REPORT REF: 217940-R07

This report is intended to verify that the Sustainable Drainage Systems (SuDS) which form part of the proposed development at Land at Ford Road, Arundel have been installed in accordance with the detailed design drawings. Conclusions have been drawn based on evidence provided by Esquire Developments including delivery notes, photographs and an as-built survey which has been compared against ACE's construction drawings.

LAND AT FORD ROAD, ARUNDEL

SuDS VERIFICATION REPORT

SECTION ACCESS ROAD CULVERT - SECTION VIEW

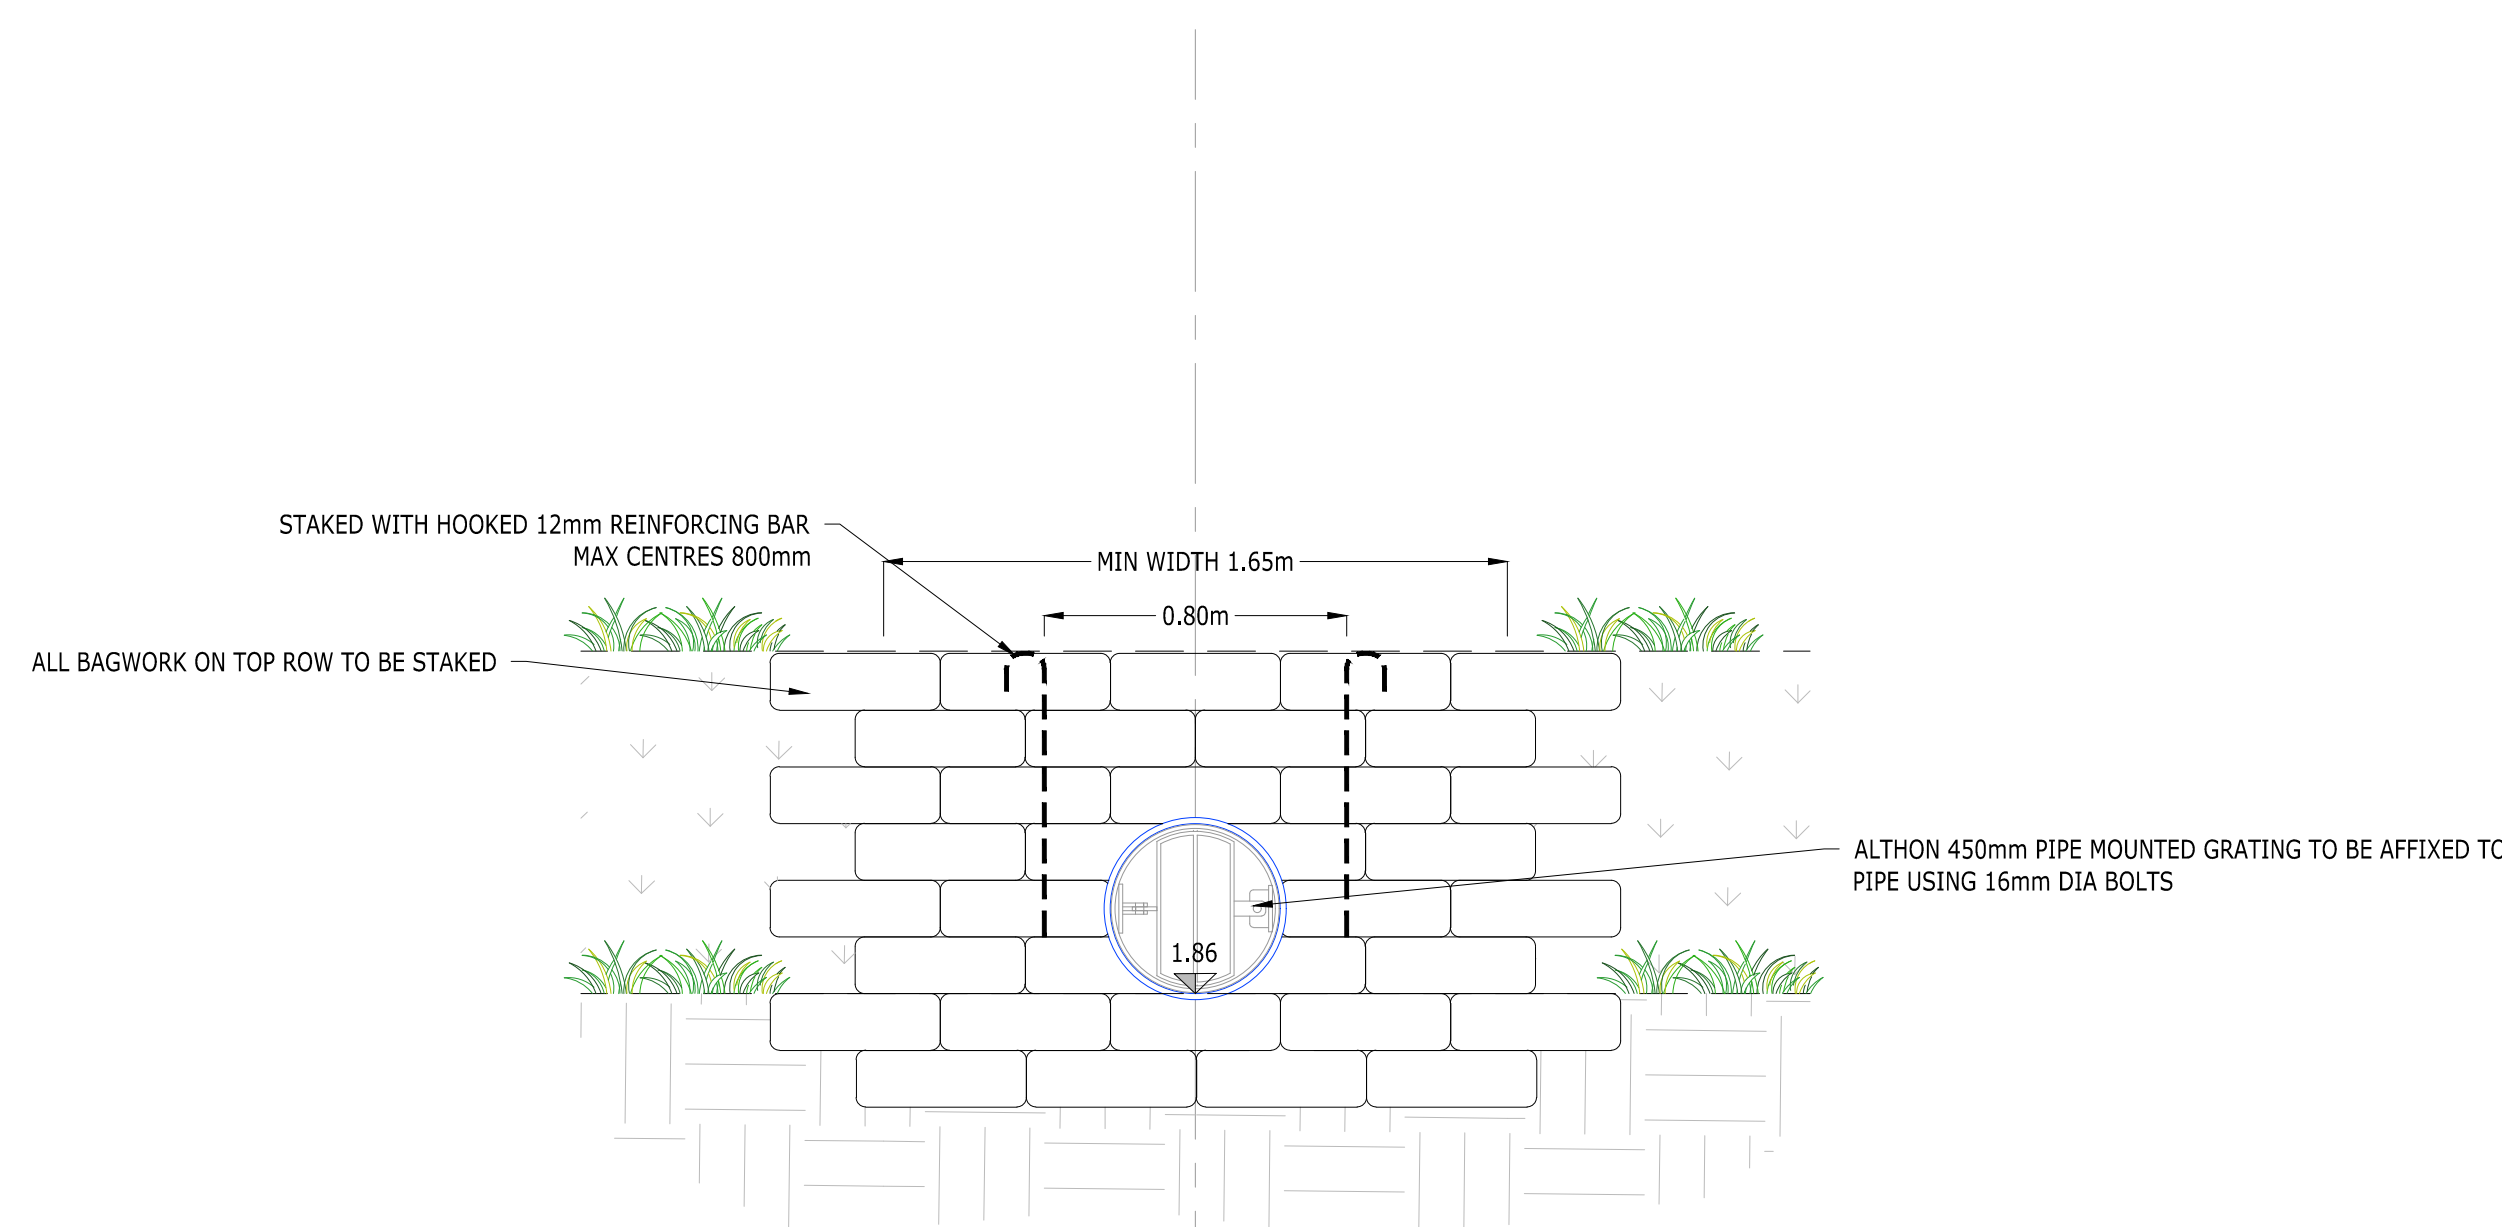
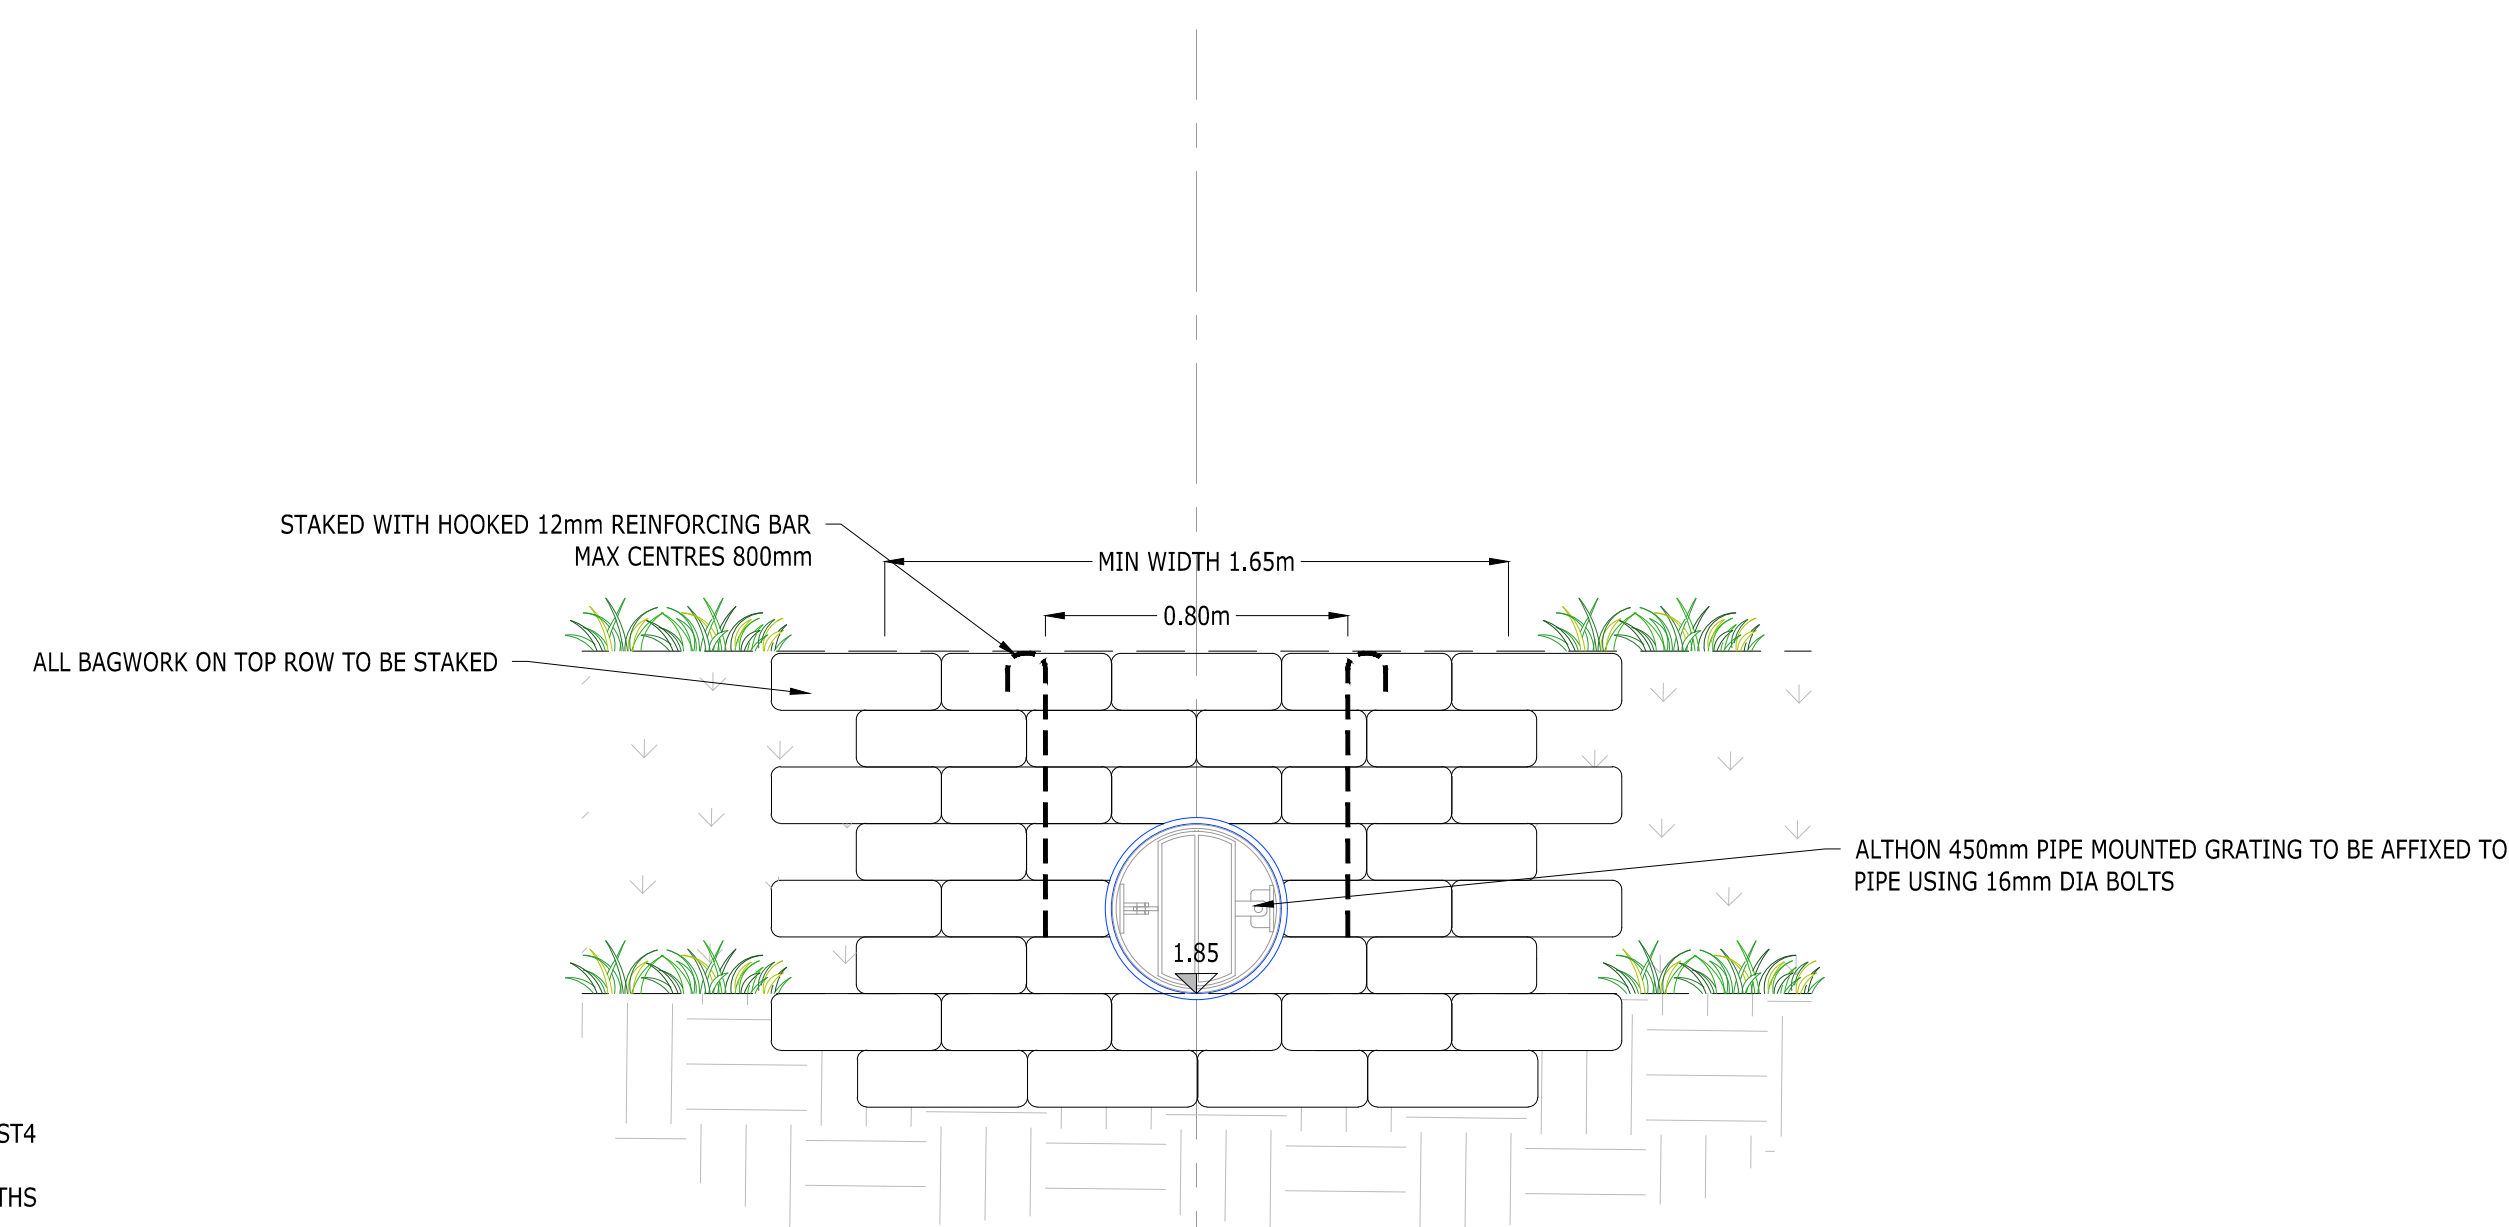
It is also noted that the balancing pipe under the access road has been installed at 300 diameter; per discussions with site it has been confirmed that this was to keep the crown of the pipe out of the bound courses of the highway, as this pipe is not intended to take excessive flows this is therefore acceptable to the designer.
